Application for a non-material amendment following a grant of planning permission.

Number	4
Suffix	
Property name	
Address line 1	Penfolds Place
Address line 2	
Address line 3	
Town/city	Arundel
Postcode	BN18 9SA
Description of site location must be completed if postcode is not known:	
Easting (x)	501235
Northing (y)	106595
Description

Reference number:	AB/60/21/HH
Date of decision	01/09/2021

6. Non-Material Amendment(s) Sought

Proposed Elevations & Roof Plan

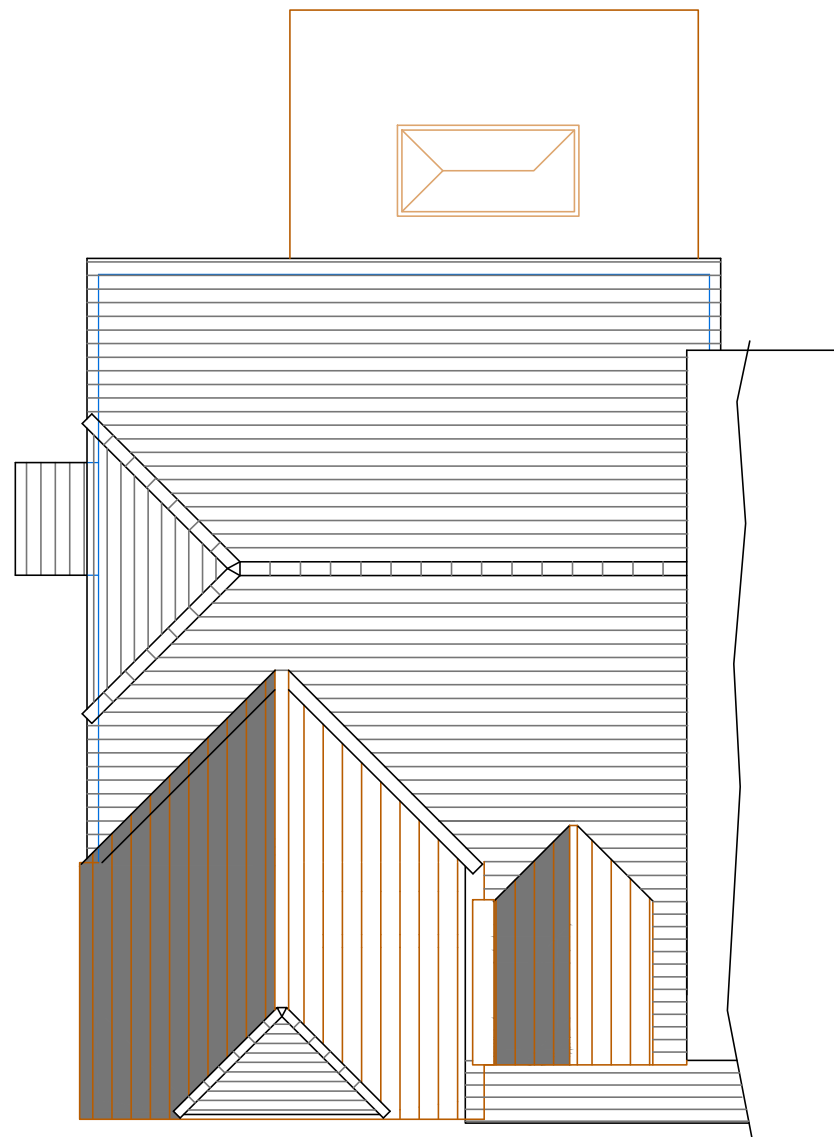
First Floor extension (bedroom 4) over garage is reduced in size bringing it away from the party wall with no. 5 Penfolds Place by 300mm. The construction will now be a timber (dormer style) construction. Effectively this is now an enlargement of the dormer. Material finish to dormer to be light grey composite Cedar board. Grey colour to match closely to the existing dormer.

The original plan gave rise to complex construction issues particularly in regard to the attachment to the Party Wall with No. 5 Penfolds Place. The new design brings the first floor extended dormer away from the party wall.
